Surface Water Drainage Technical Note		
Project Name & Number:	Condair, Brookside Avenue	D2287
Subject:	Surface Water Drainage Technical Note	
Client:	Condair Ltd	
Prepared by and Date:	S Burnett	07/05/2025
Planning Reference:	R/239/24/PL

The surface water drainage strategy has been re-assessed in view of site constraints and a revised proposal is included within this technical note (drawing **PL500 Rev. A – 'Proposed Drainage Strategy'**).

Drawing No. Rev.
000-BPC-WD-ZZ-D-C-PL400 A

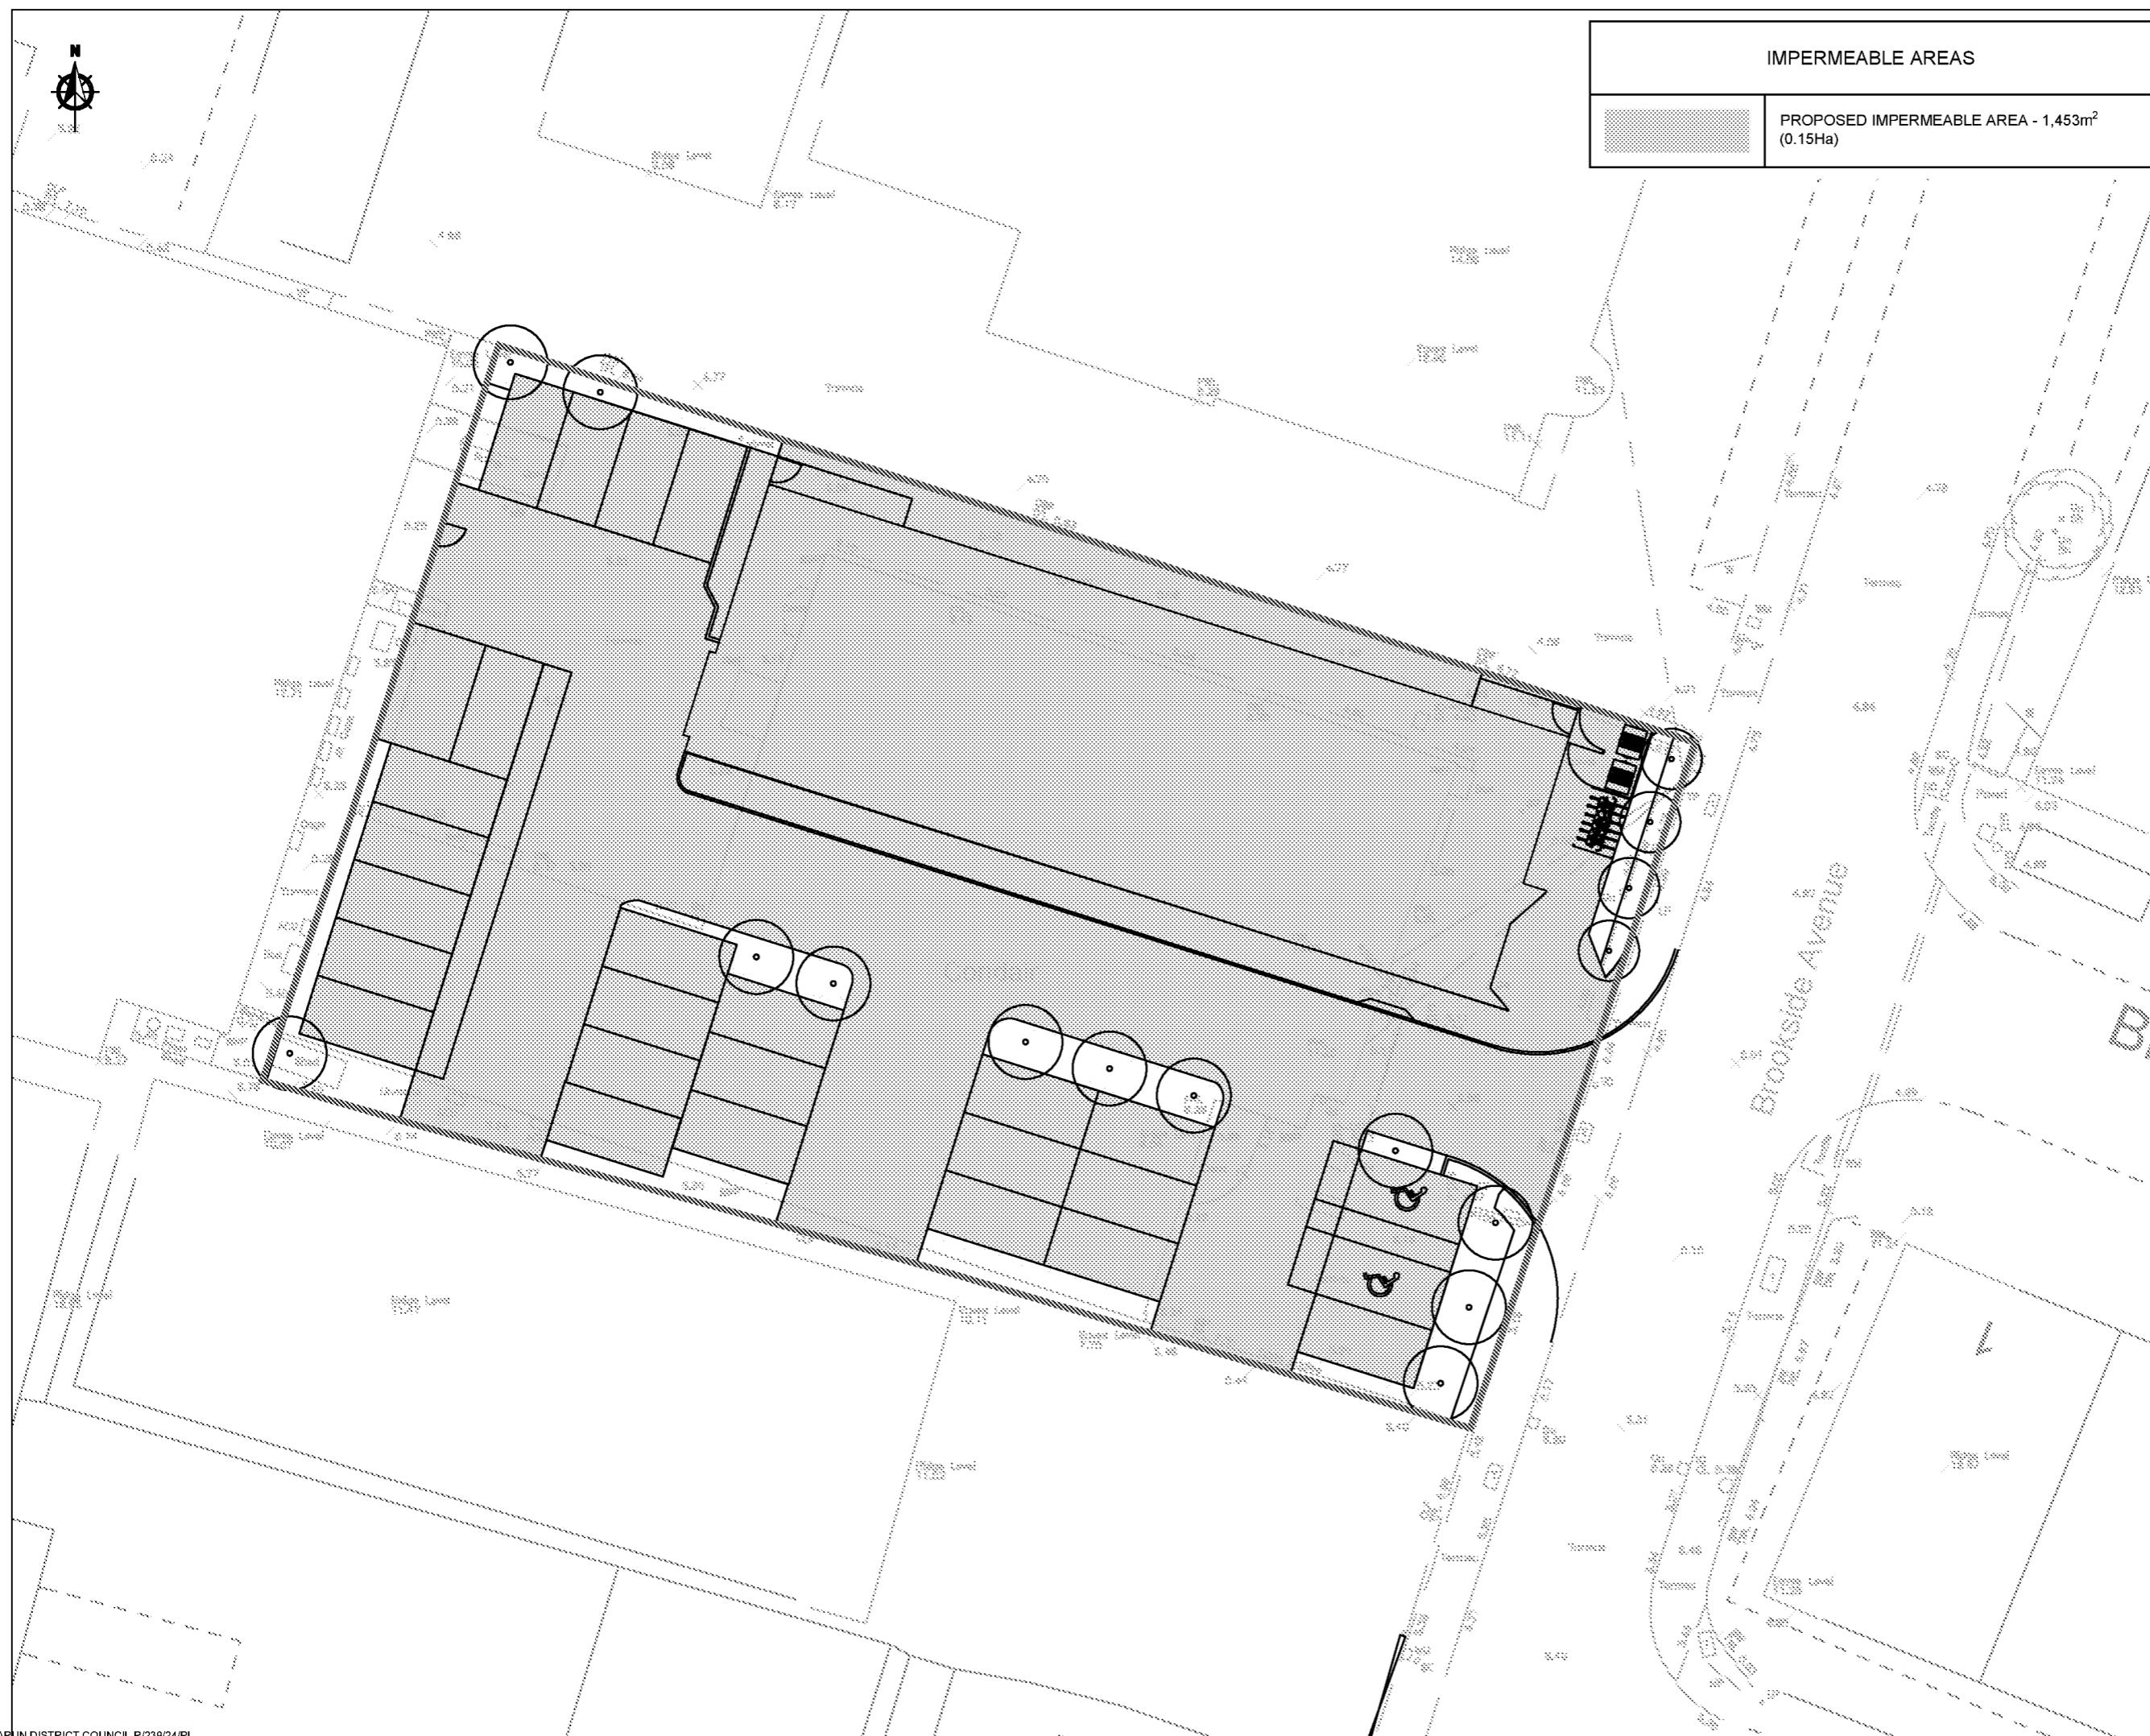
The site apparently disposes of surface water to the public foul sewer, evidence of this has not been fully submitted, although it is not disputed at this stage. Additional surface water is said to flow overland towards the highway where it discharges informally to the highway drainage network via road gullies. Evidencing this informal connection will be critical in agreeing a formal connection with the asset owner, West Sussex County Council.
